I write again on behalf of 20023052 and 20023053, relating to the Highways England A1 Birtley to Coal House Improvement Scheme (TR010031).

For today's deadline, D3, we would simply like to reiterate our concerns regarding the placement of the gantries and the potential impact on views to the Angel of the North. Our comments relate to the Applicant's responses to the Examining Authorities Written Questions, and the Applicant's responses to Relevant Written Representations.

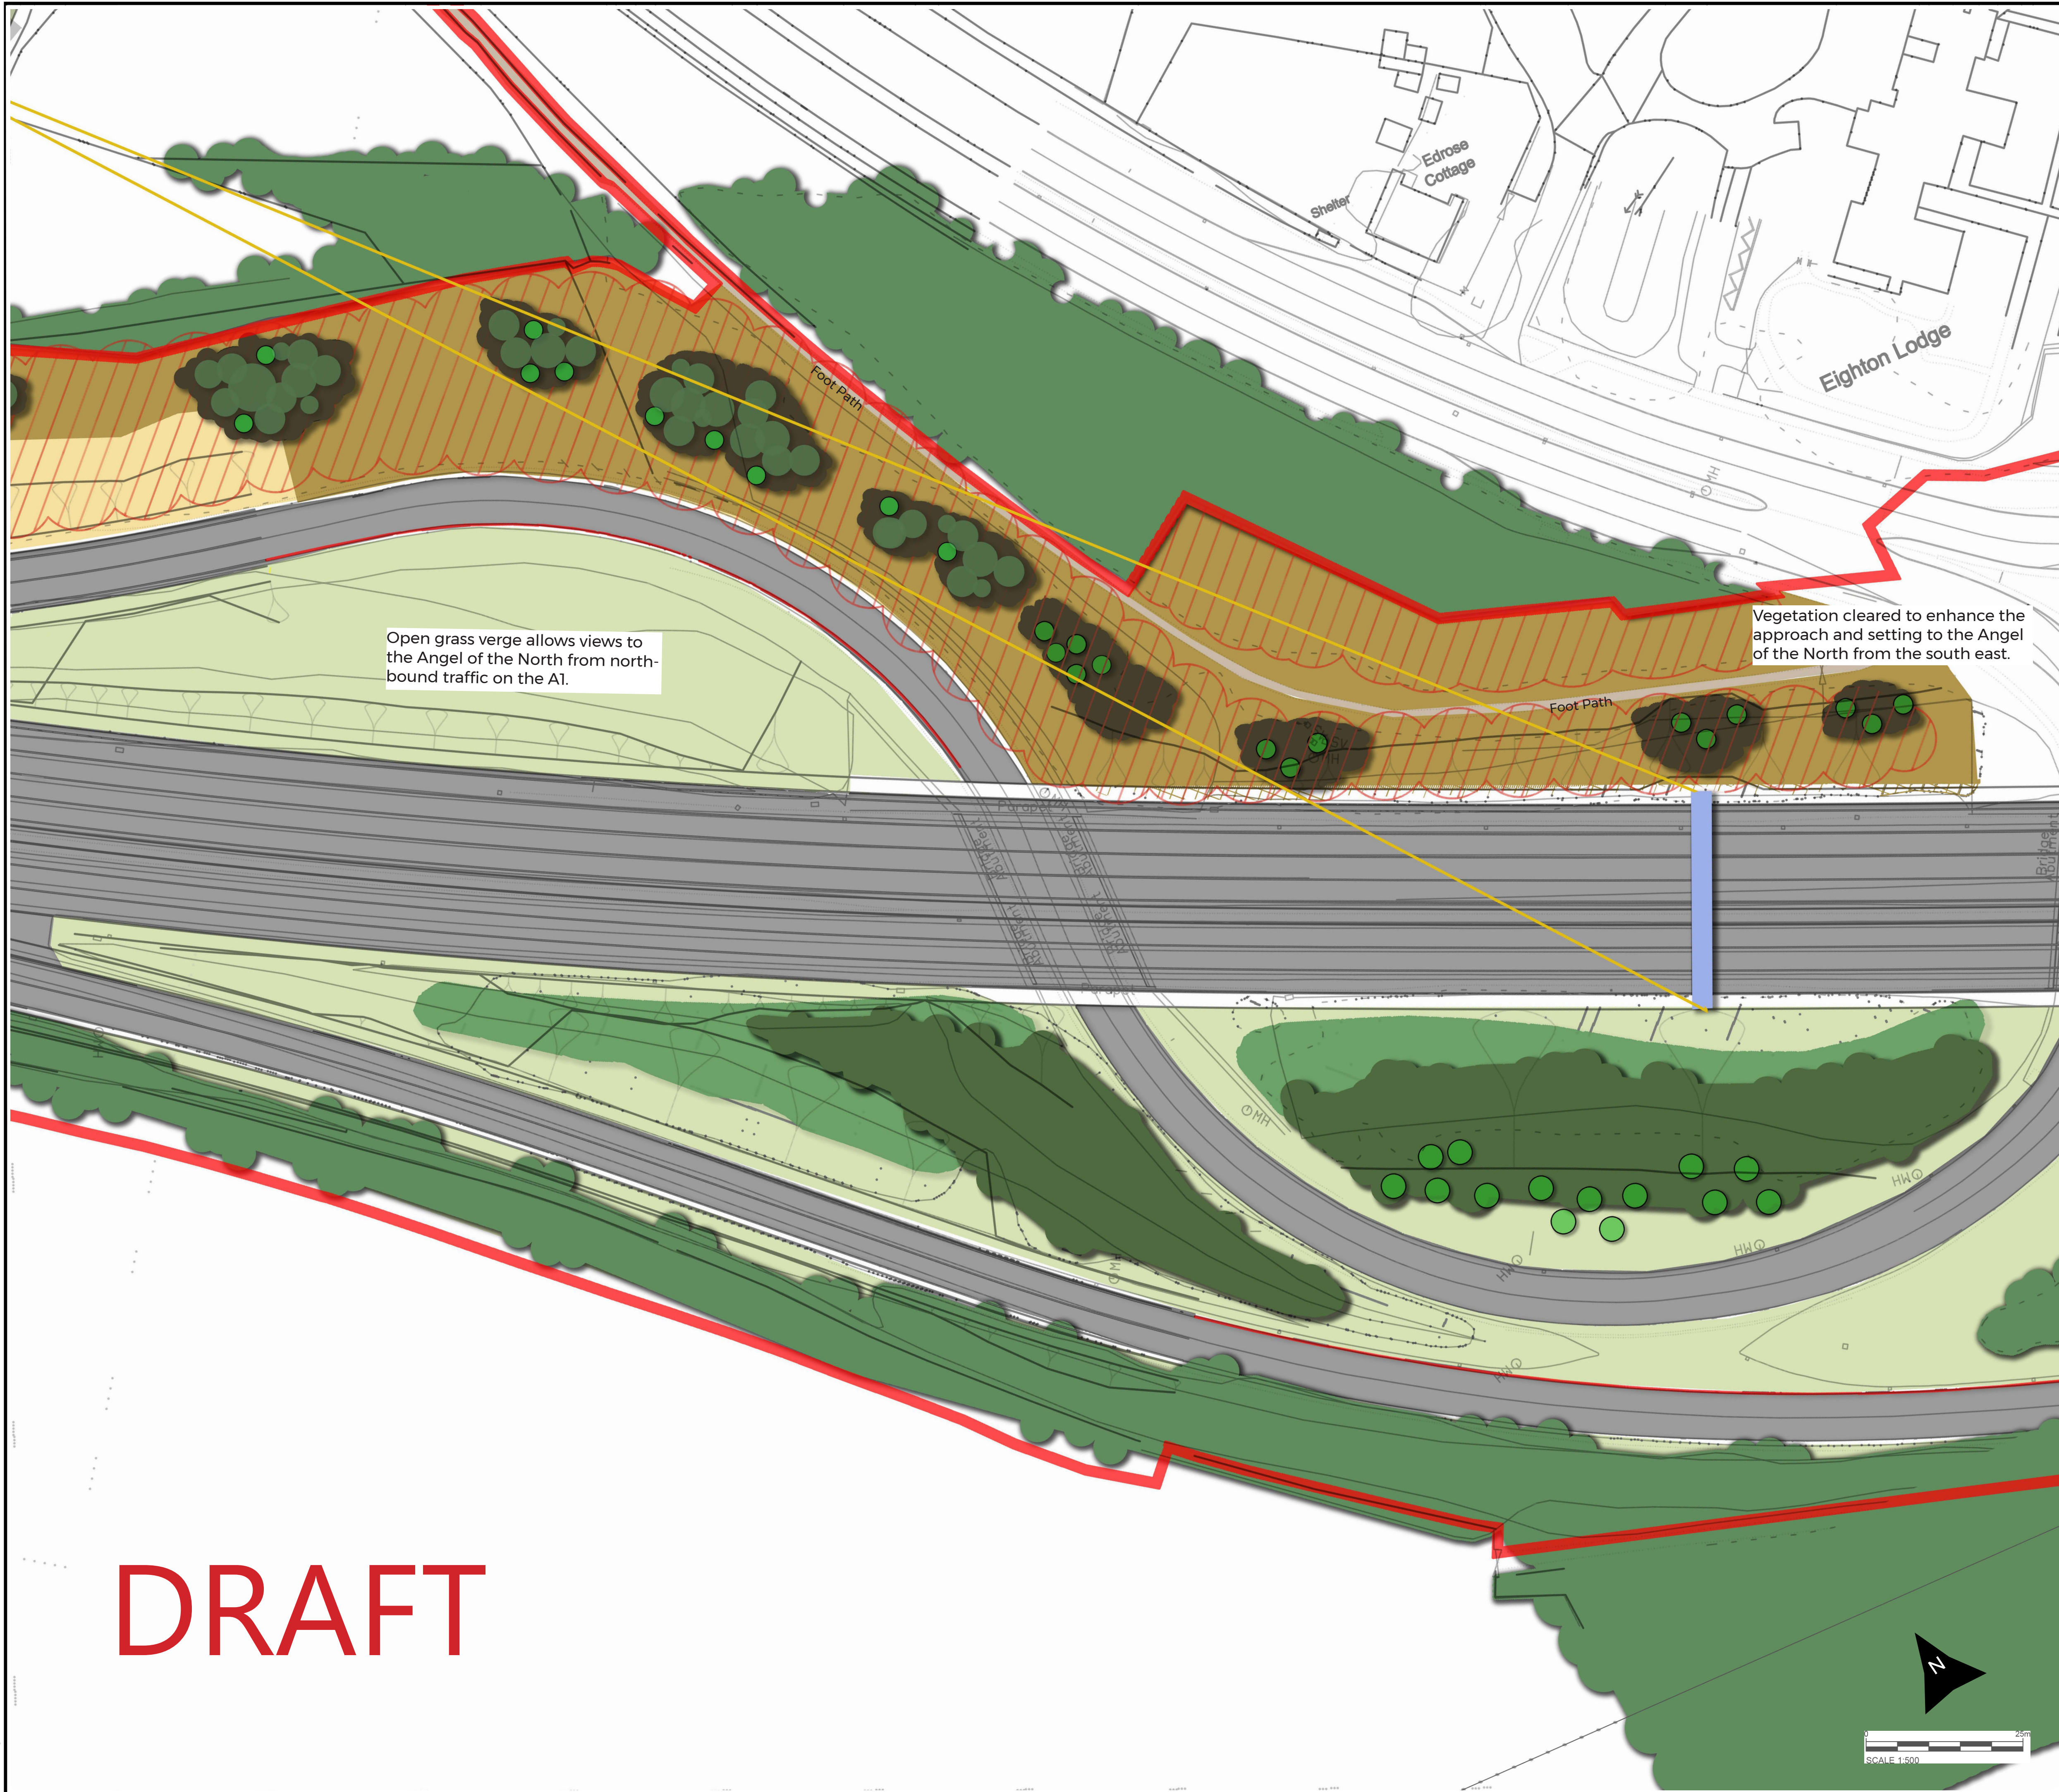
However, we feel that the number of gantries, and in some cases gantries that span the entire width of the road, in the approach to the Angel of the North from the South on the A1 is significant.

Again, we would like to reinforce our concerns that the footbridge structure in combination with the gantries may have a detrimental effect on views towards the Angel of the North from the A1 Northbound.
